Reference: #12S9018500

**RE: REDEVELOPMENT OF THE IMAX THEATRE AND SURROUNDING PUBLIC DOMAIN UPGRADES DARLING HARBOUR (SSD 7388)**

This letter is provided in response to matters raised by Transport for NSW (TfNSW) in their letter dated 8 March following review of the Transport Impact Assessment prepared by GTA Consultants as part of the above development application.

LONG RIGID BUS metres

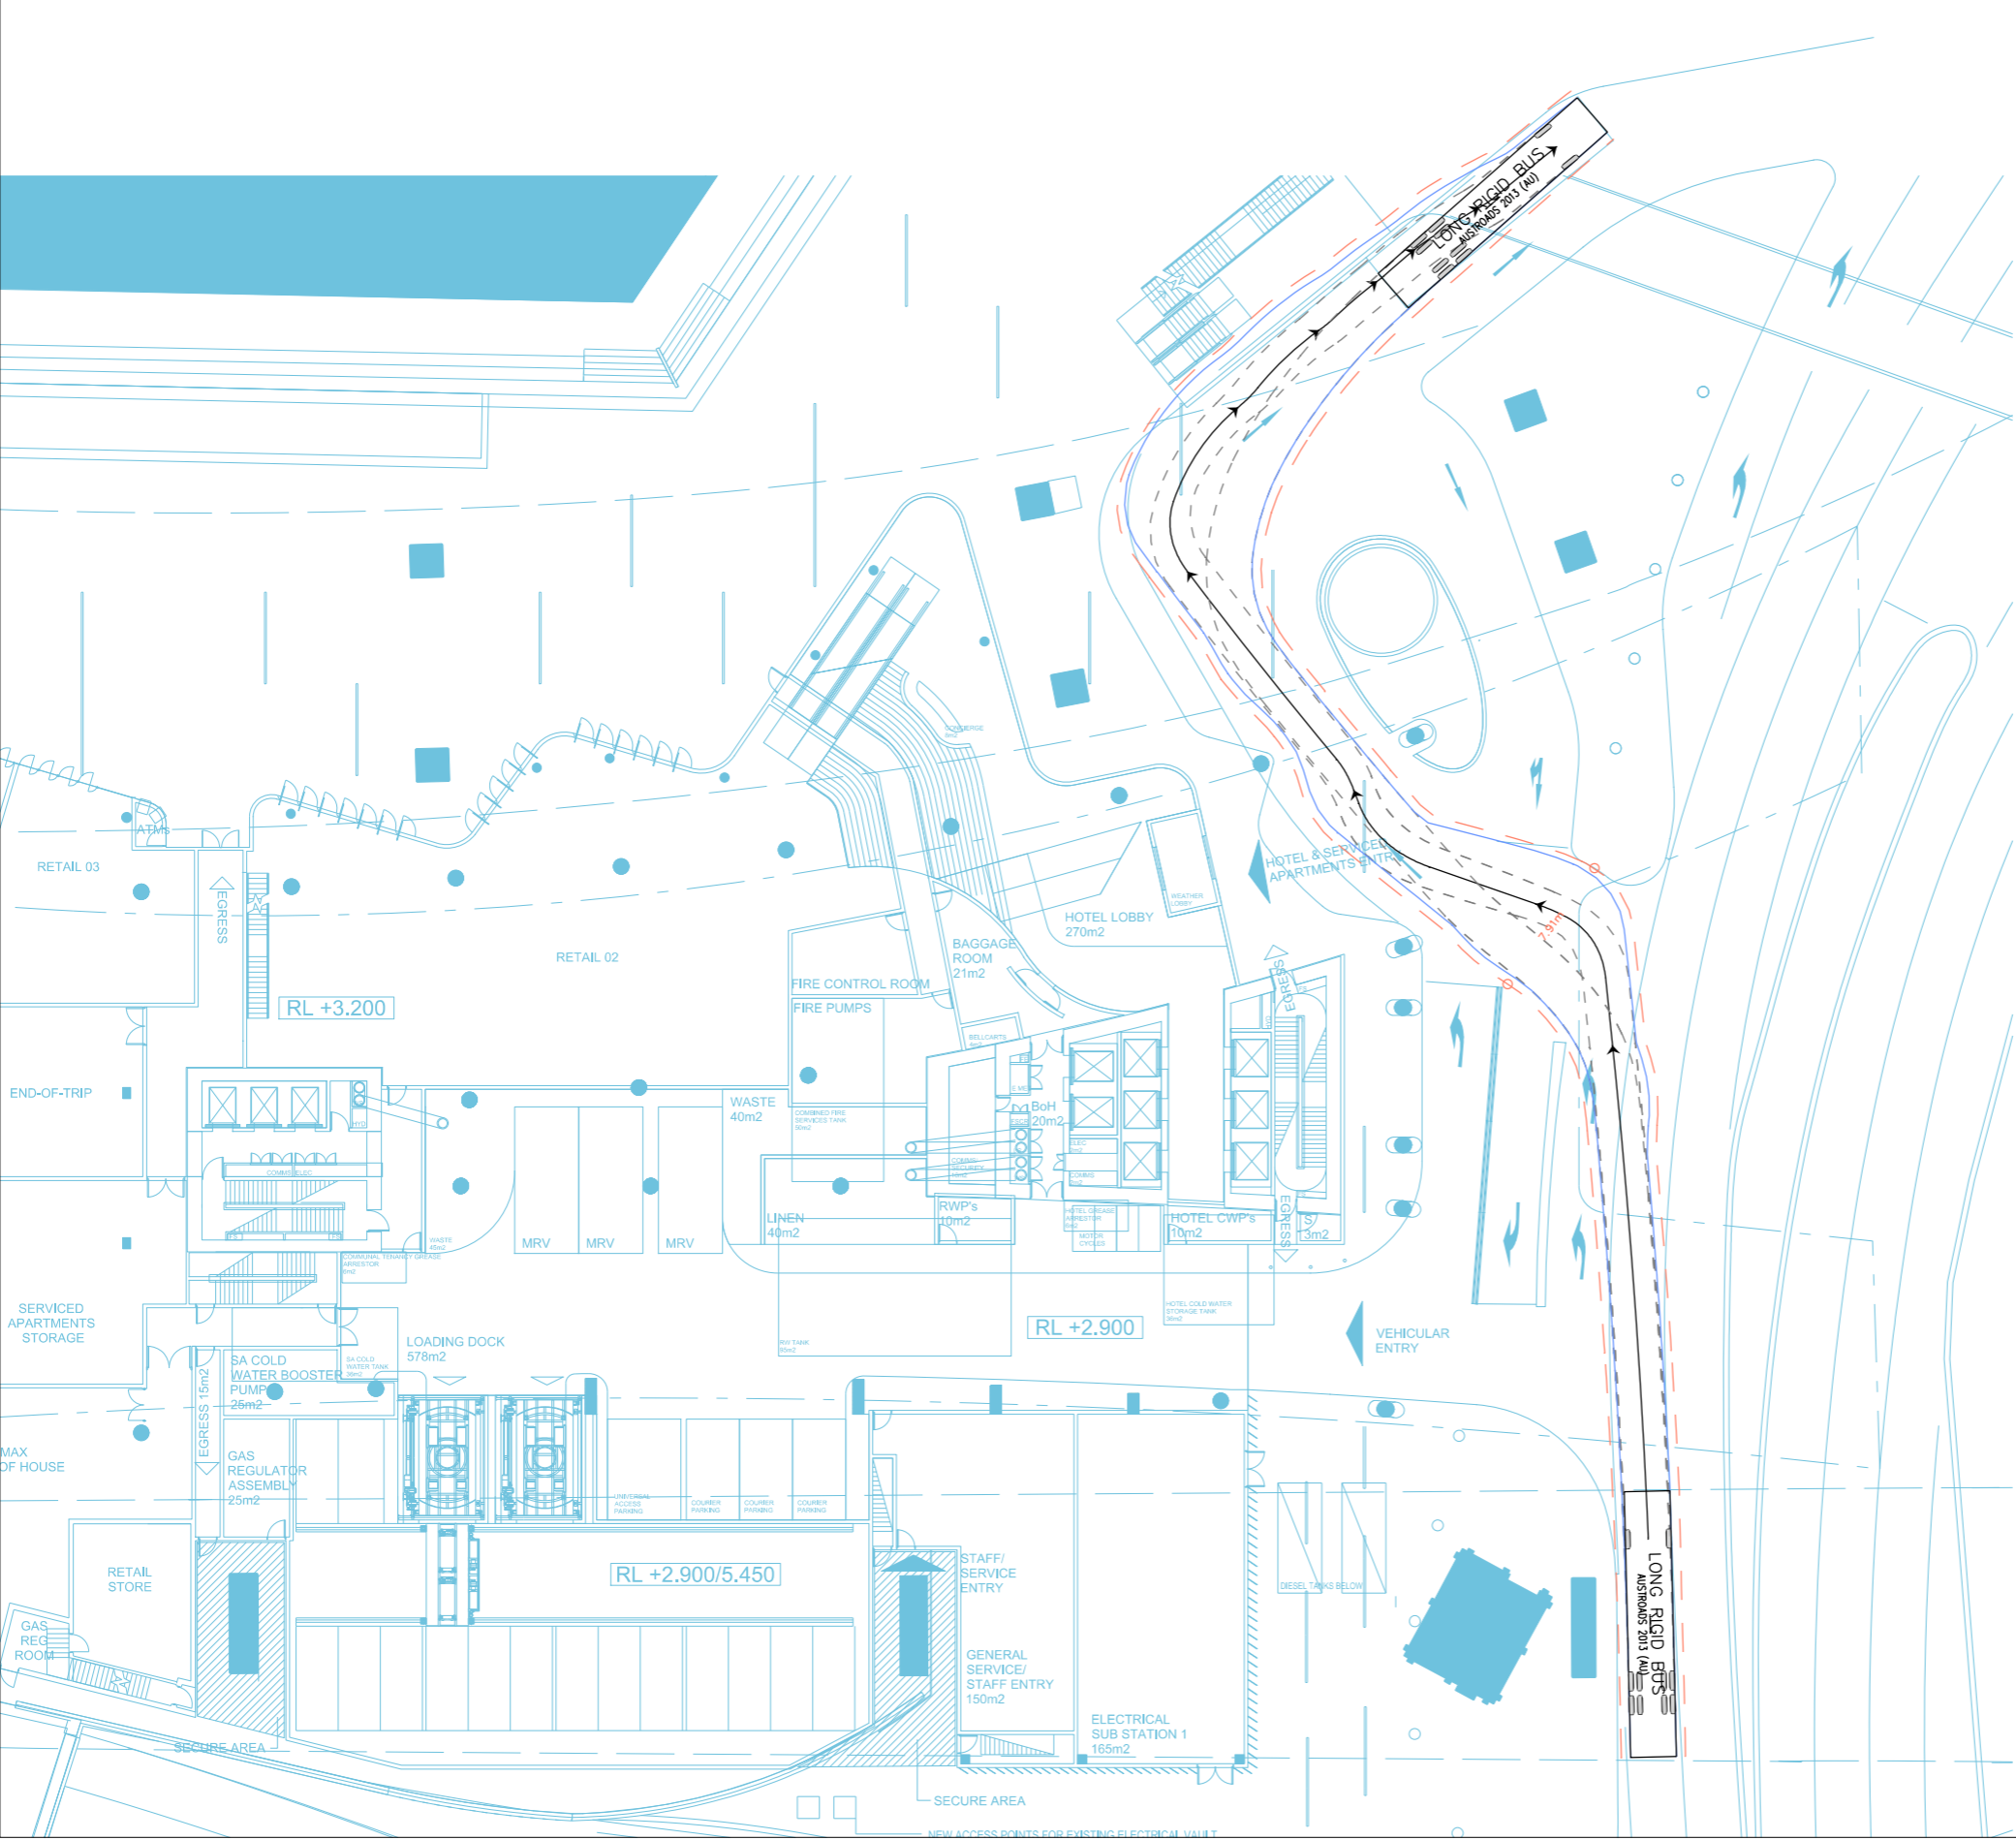
*In addition, swept turning path shows that a bus will not be able to pass if another vehicle has already stopped in the porte cochere. It also shows that a bus will not be able to make the last turn near the pedestrian bridge steps as indicated on the plan.*

The vehicle positions shown within the porte cochere vehicle bays are indicative only. The bus swept path is a worst case situation (14.5m long rigid bus which are not used the Sydney Explorer service and would only be occasional pre-arranged coaches for the hotel). The swept path analysis shows there is adequate spare width within the porte cochere area for a 14.5m long rigid bus to pass parked vehicles, however the resultant vehicle positioning at the bus stop would be considered further during detailed design to deliver an appropriate outcome.
